# OFFICERS REPORT

APPLICATION No: S6/2000/603

DESCRIPTION: Erection of first floor side extension and single storey rear extension

LOCATION: 381 St Albans Road West

**PROPOSED ELEVATIONS
 FRONT/ REAR & SIDE ELEVATIONS**

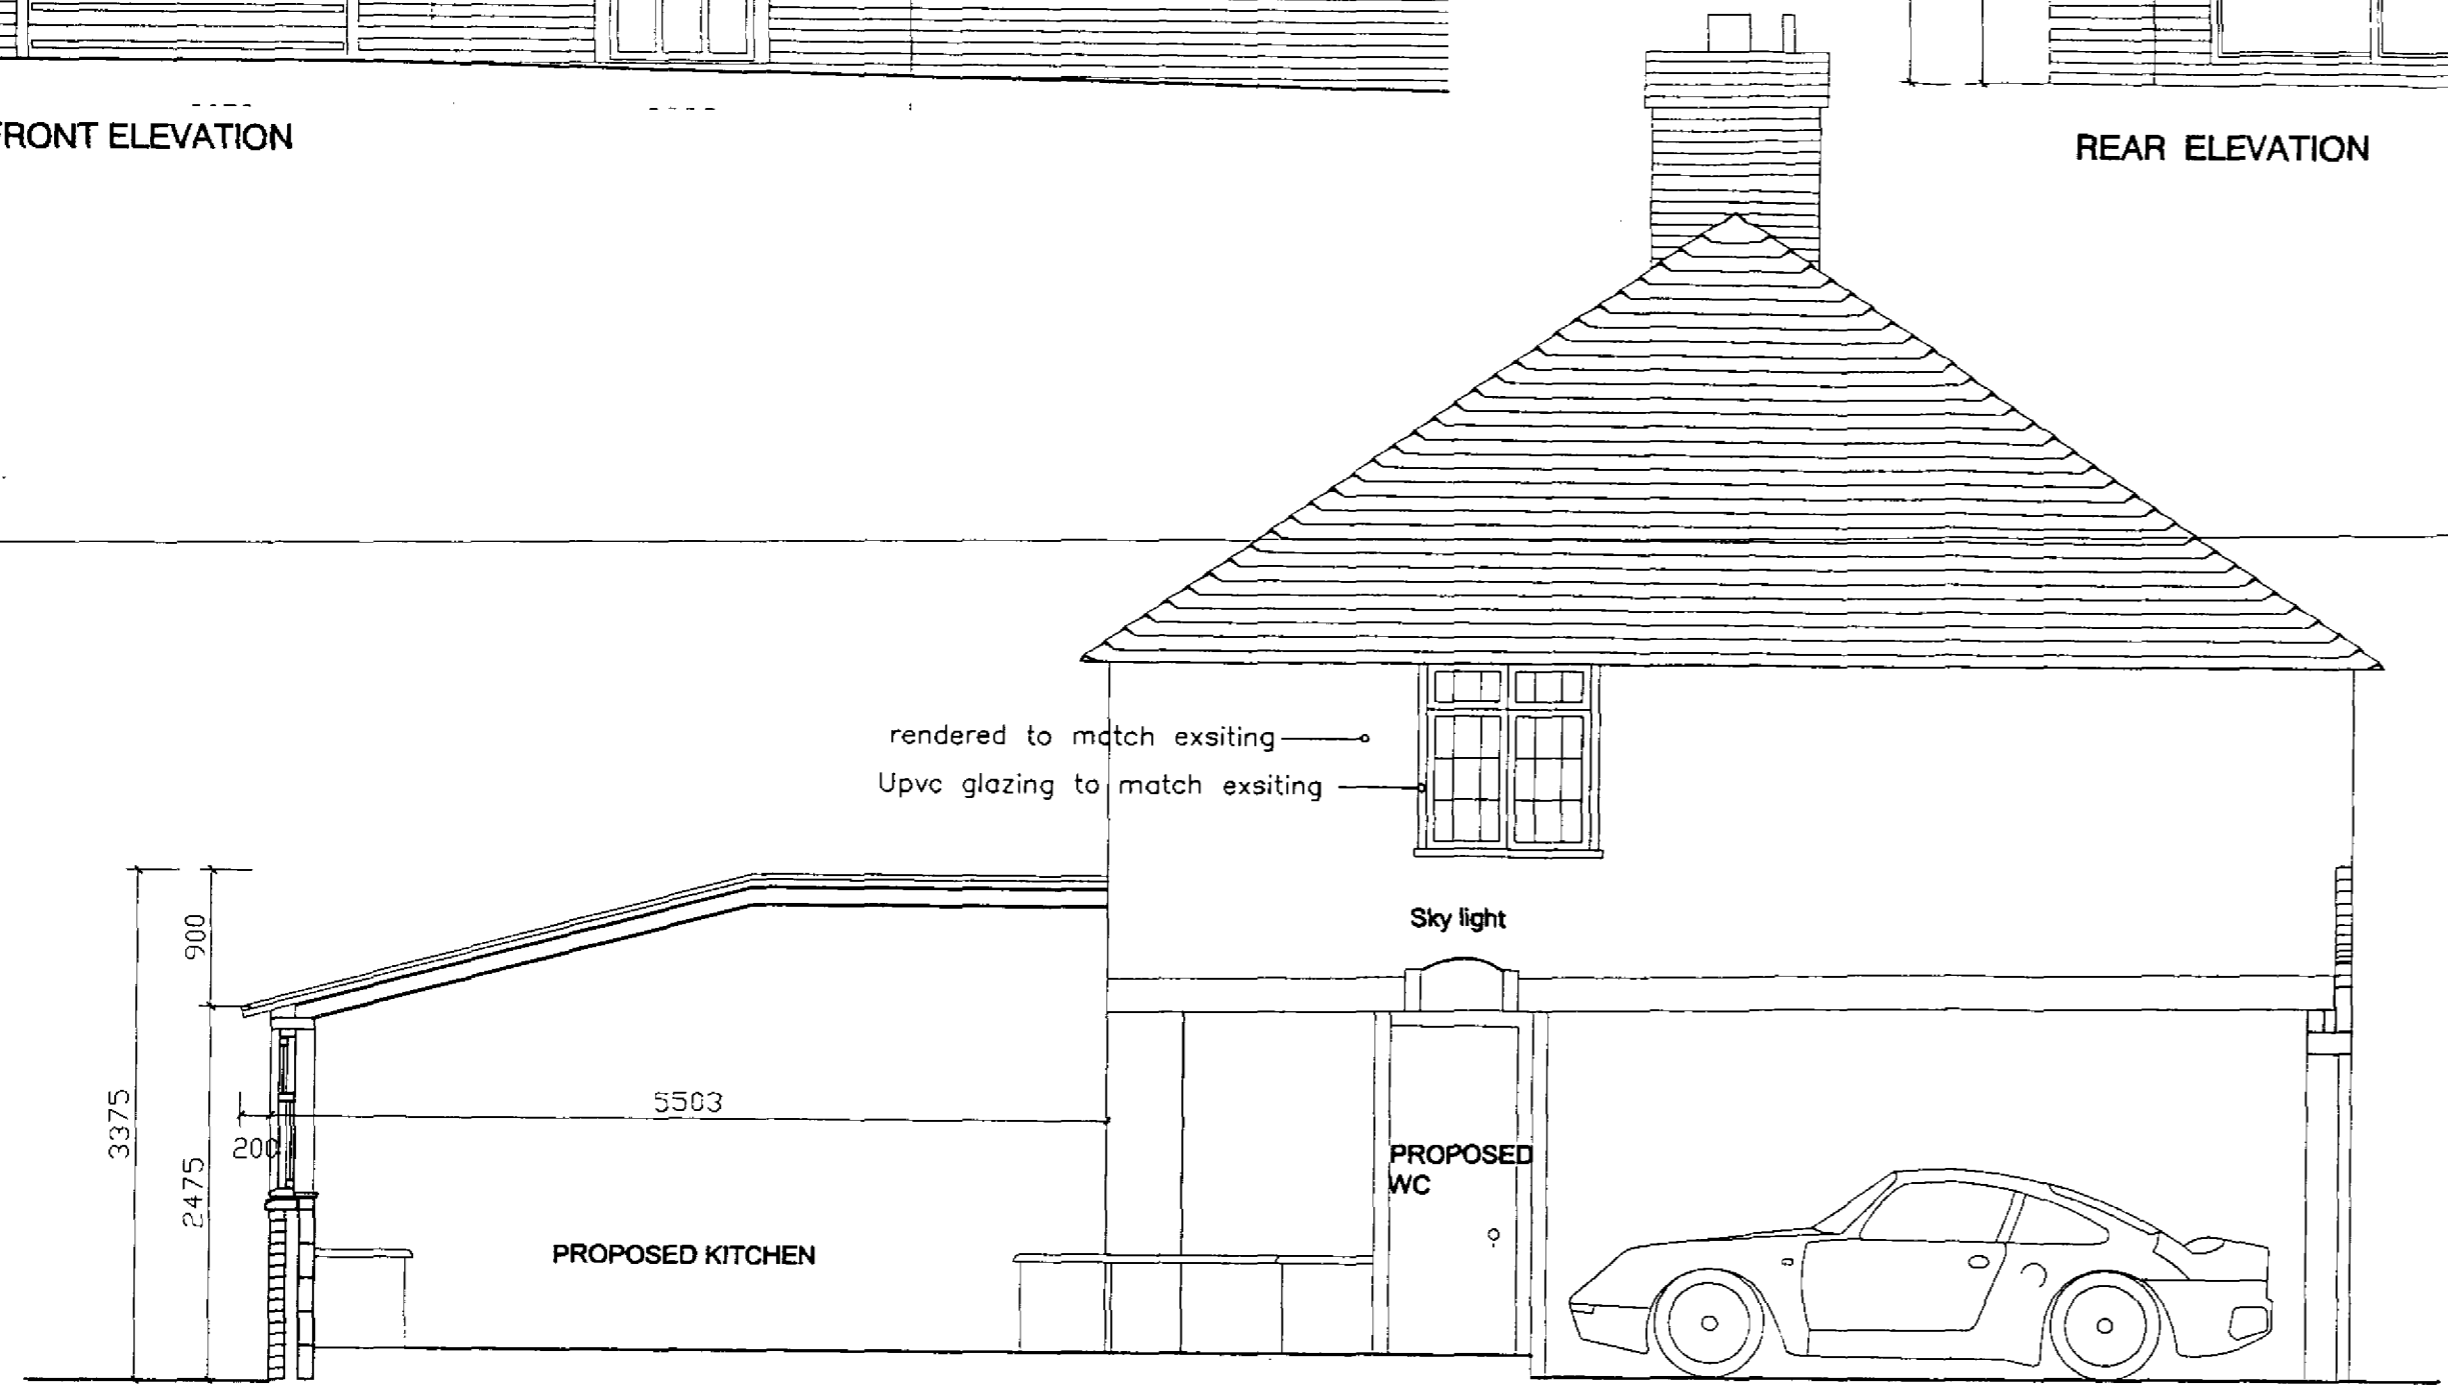
The first floor side extension is located 1m from the boundary and as such meets the criteria given in Appendix A of the district plan. The side window to the extension could be required to be obscure glazed so as to prevent any possible overlooking. The roof to the main dwelling will remain at the same pitch and style and so I do not consider that the extension will appear dominant or incongruous within the street scene. There are also other examples of this type of development within this part of St Albans Road West.

**PROPOSED PLANS
 GROUND / FIRST FLOORS**

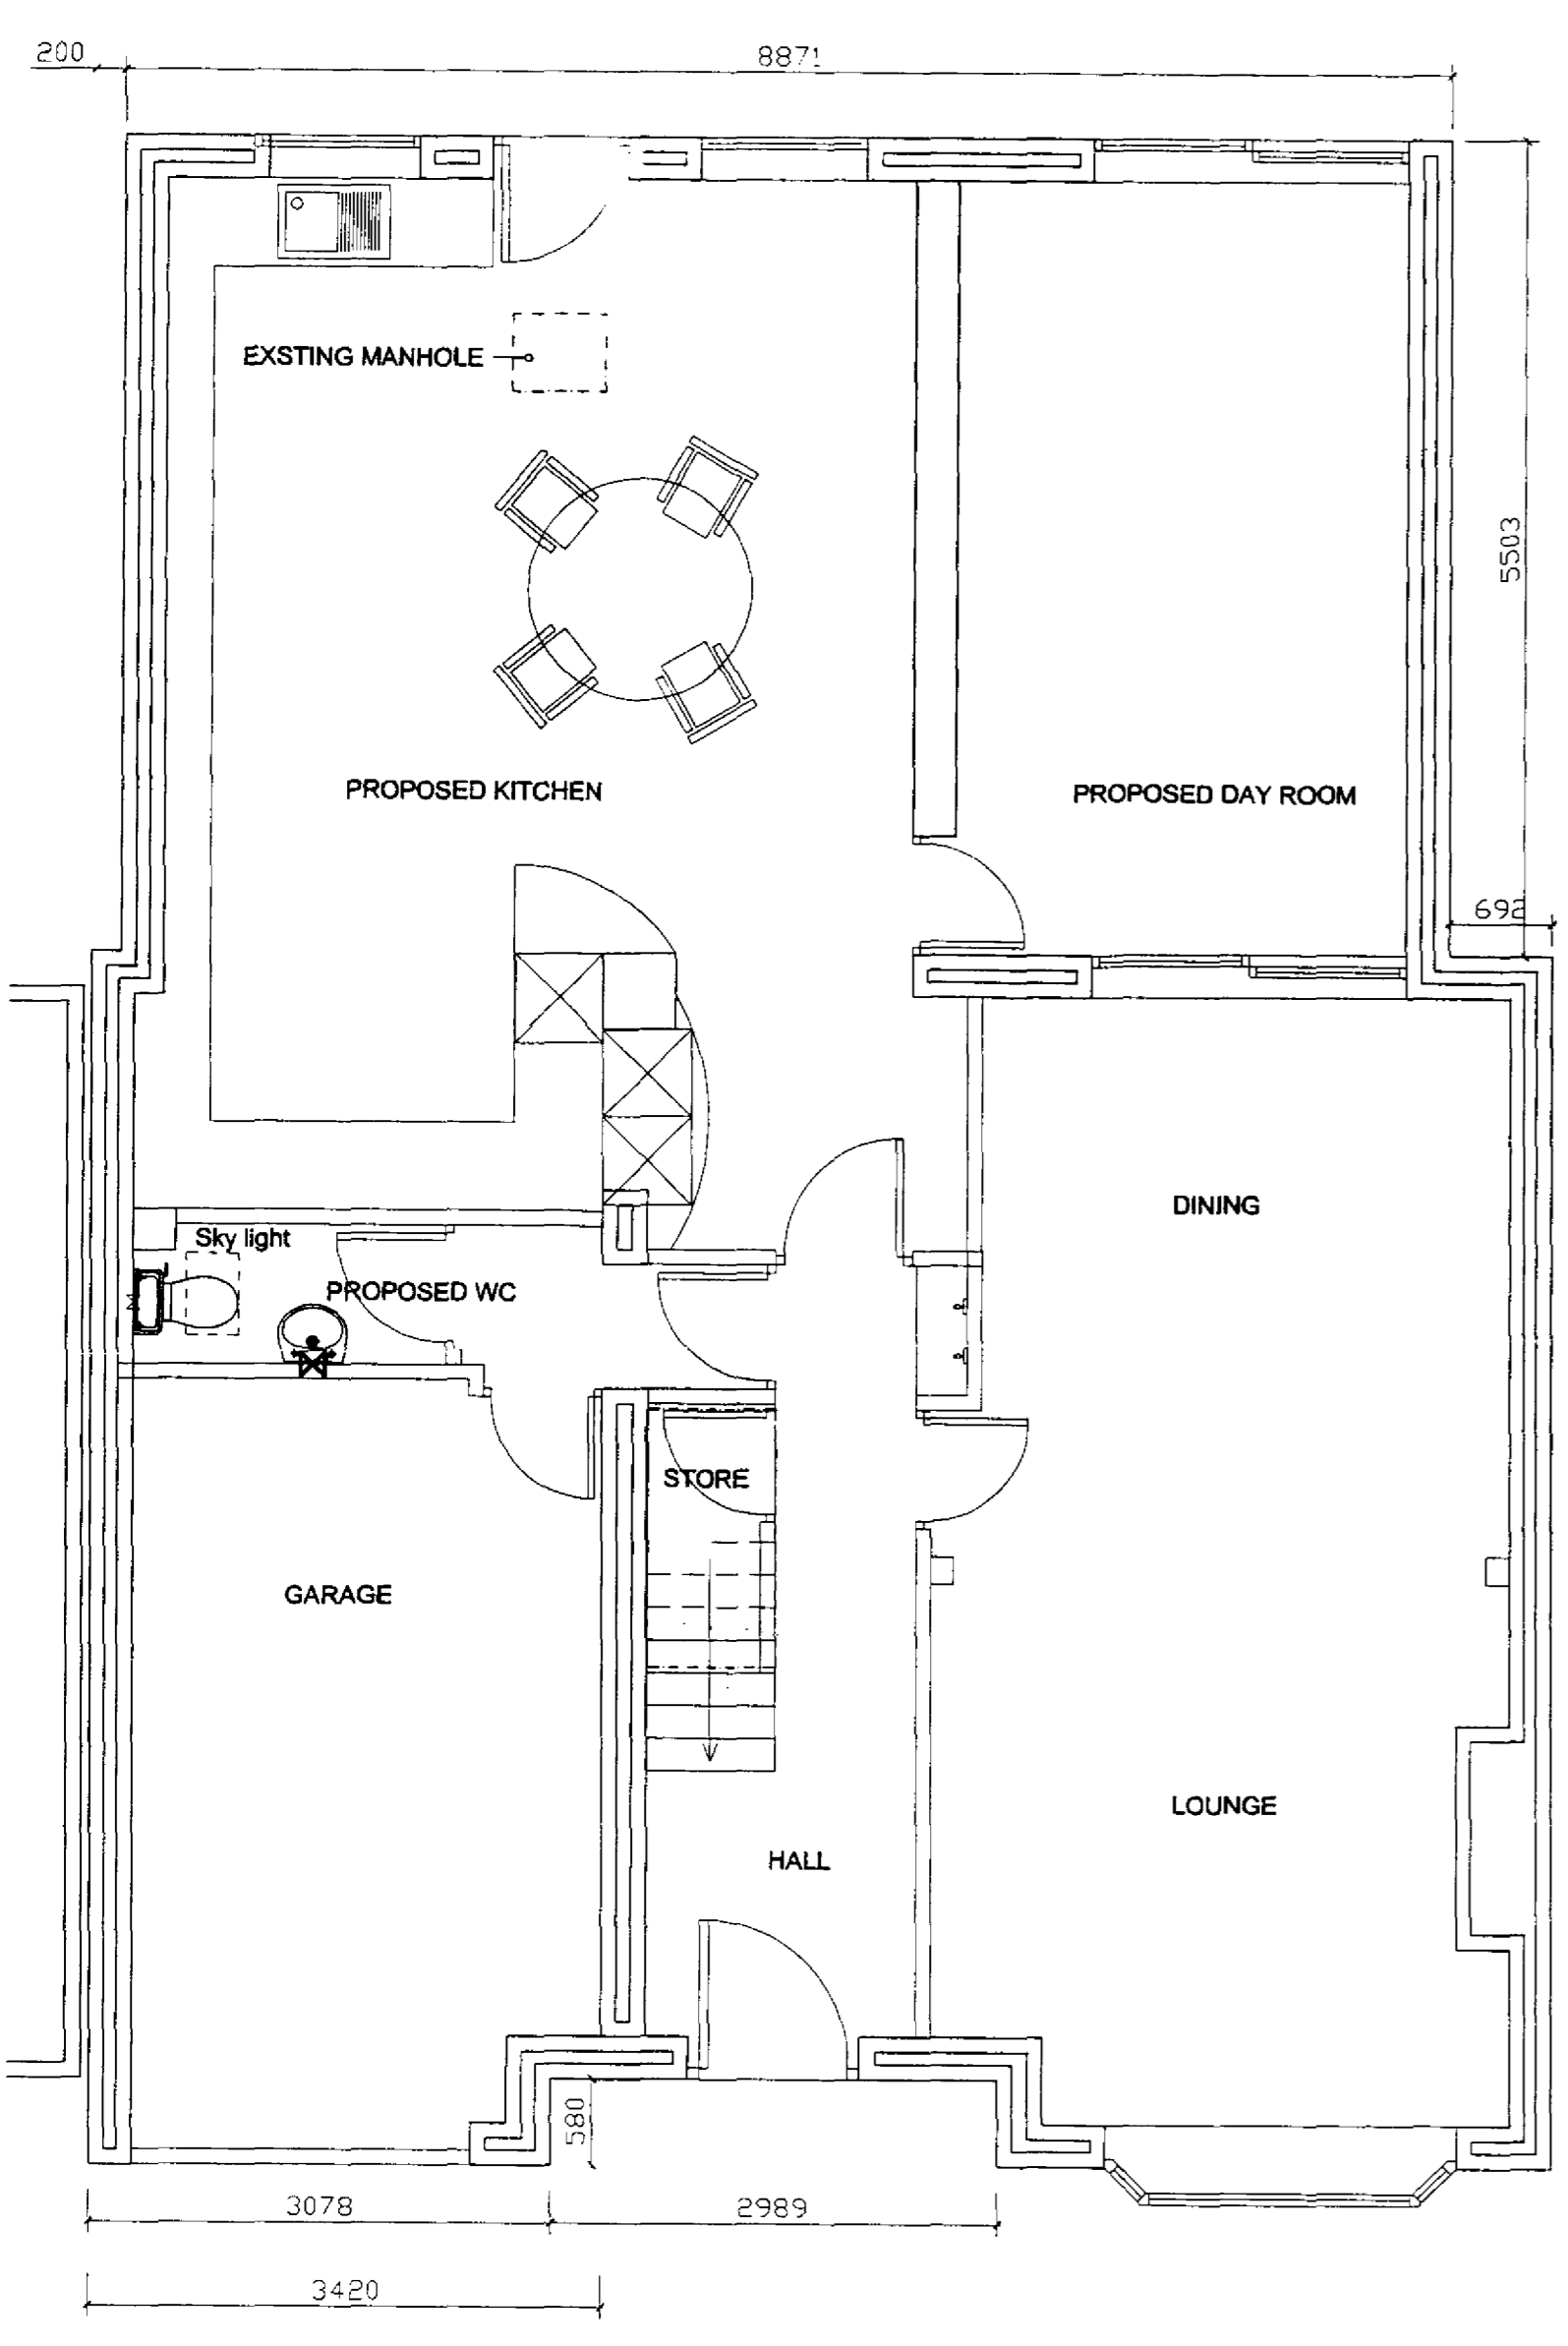
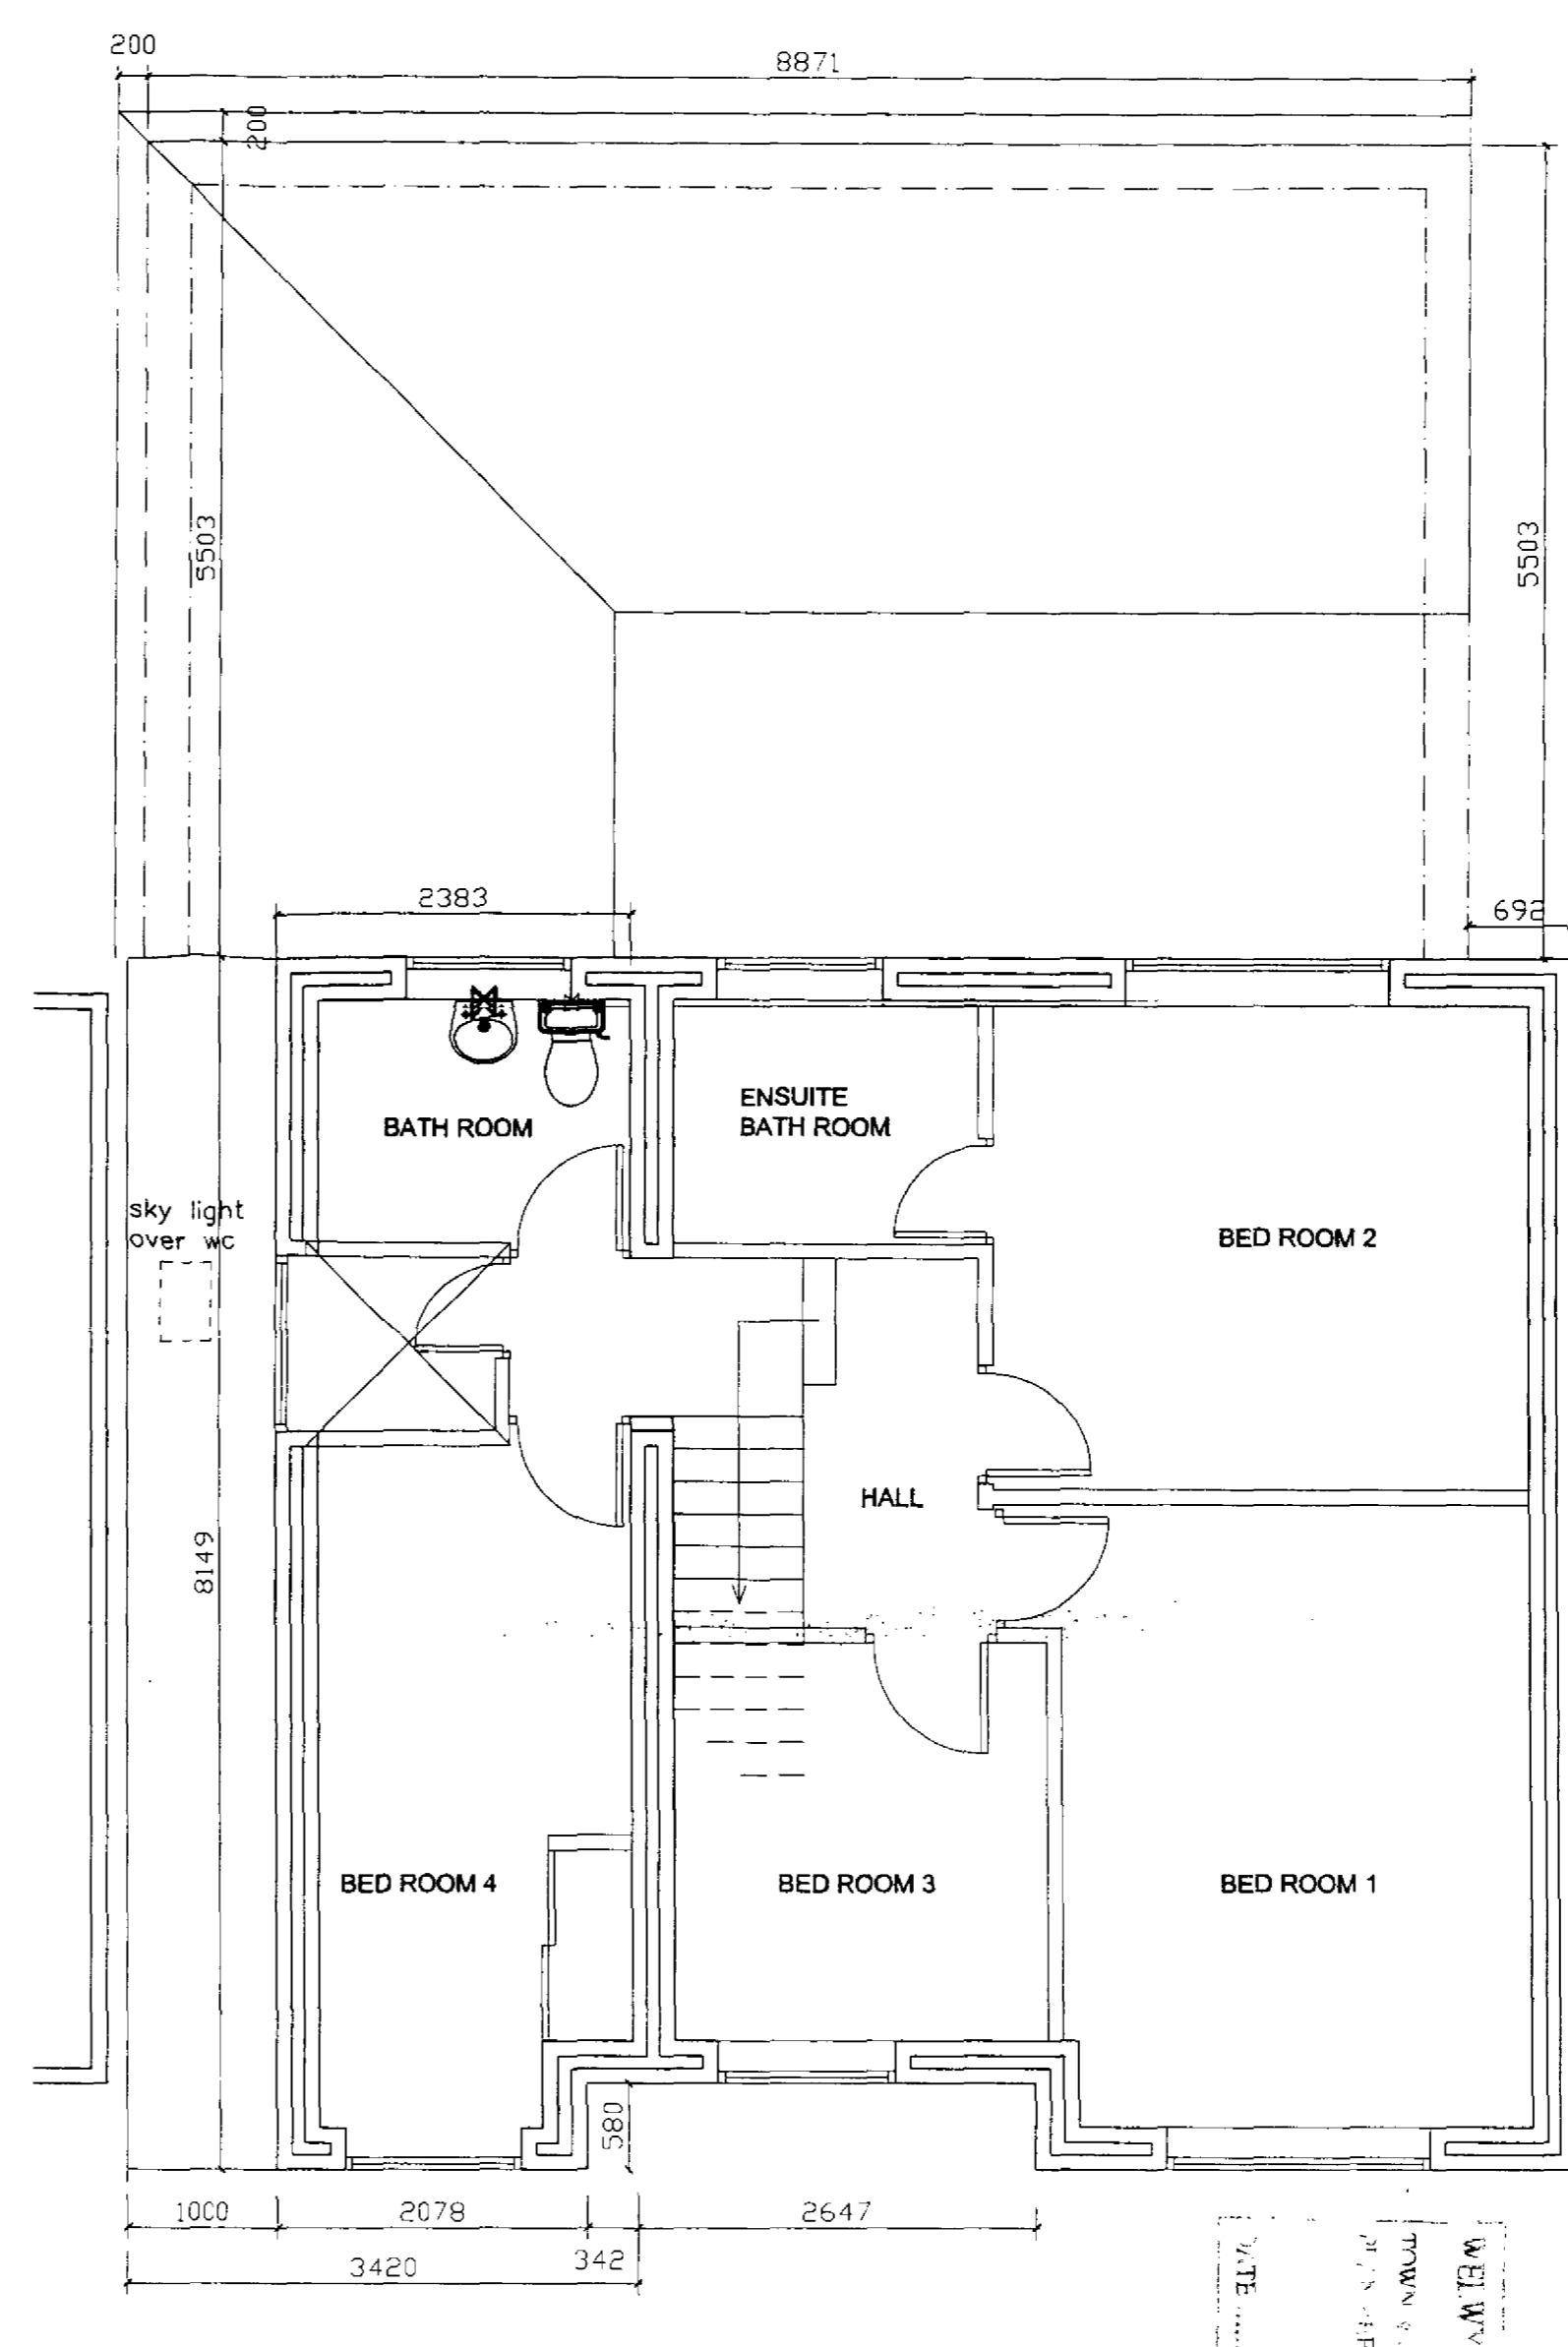
The rear extension is large in size although the design incorporates a pitched roof, which is preferable. The other half of the pair of semi detached houses has had no rear extension, but has a set of patio doors located 0.8m from the boundary. There is however a 2.2m high fence between the two dwellings and mature landscaping along this boundary. The extension would therefore be difficult to view from this property.

The ground floor rear extension is bordering on being too large in size, however, the impact it may have on either of the adjoining properties is limited due to the south facing aspect of the rear gardens and the boundary treatment between the dwellings.
